WEST SUSSEX COUNTY COUNCIL CONSULTATION

TO:	Arun District Council FAO:David Spring
FROM:	WSCC - Highways Authority
DATE:	21 January 2020
LOCATION:	51 Falkland Avenue Littlehampton BN17 6AB
SUBJECT:	LU/2/20/PL Conversion of house into 3 No. self contained flats.
DATE OF SITE VISIT:	n/a
RECOMMENDATION:	Advice
S106 CONTRIBUTION TOTAL:	n/a

Block Plan

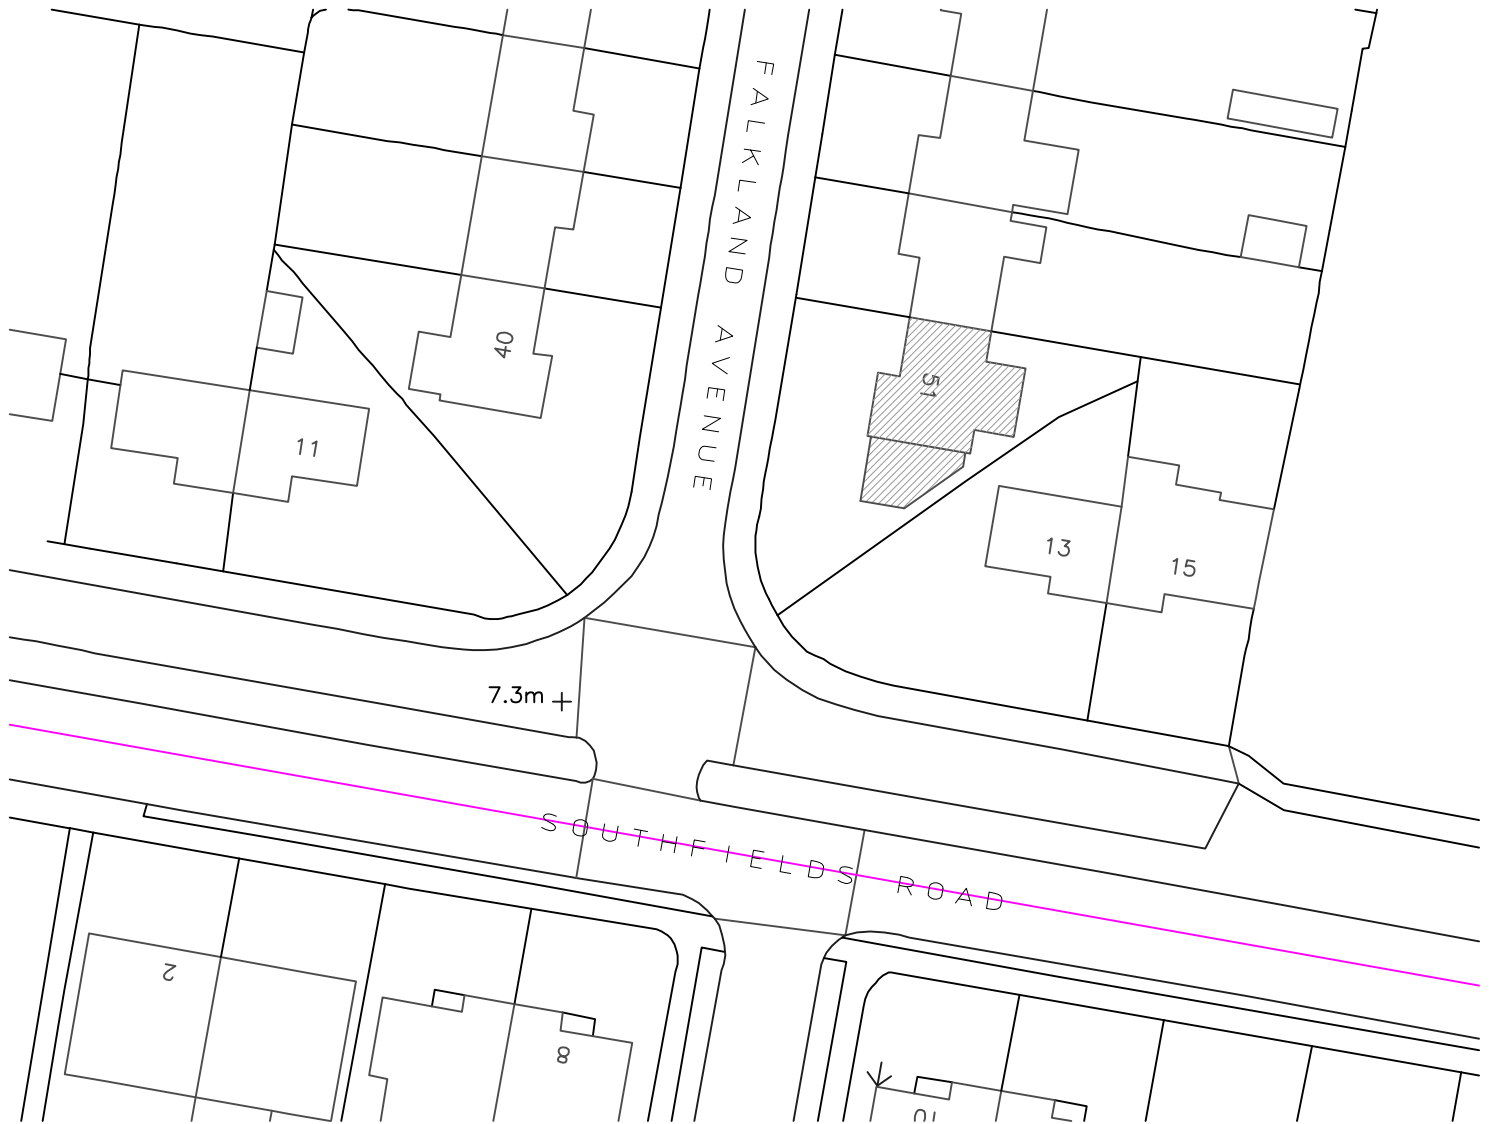
This proposal includes construction of two additional vehicle crossovers (VCO) to accommodate the proposed parking provision. I have consulted the Area Manager to provide their comments in relation to the proposed VCO. They have advised that rather than two separate VCOs, the full height kerb between the two proposed VCOs should be dropped, providing a wider, shared VCO. Any access works onto the public highway must be constructed under a licence obtained from WSCC Highways to a specification agreed with them.

Visibility splays at the proposed VCO have not been provided. Ordinarily, for 30mph speed road visibility splays of 43m in each direction would be required as outlined in Manual for Streets (MfS) guidance. Local mapping indicates that visibility splays are restricted in both directions. However, due to the presence of the approaching junction with Southfields Road, vehicles entering/exiting Falkland Avenue are not anticipated to travel at the posted speed limit. The presence of the hedge to the north of the site and the presence of the bins and the hedge between the proposed parking spaces, may obstruct visibility splays. It should be noted that any site boundary treatments should not be greater than 0.6m in height to ensure that maximum achievable visibility for pedestrians and vehicles is achieved. The LPA may wish to consider the potential visibility restrictions when deciding this application.
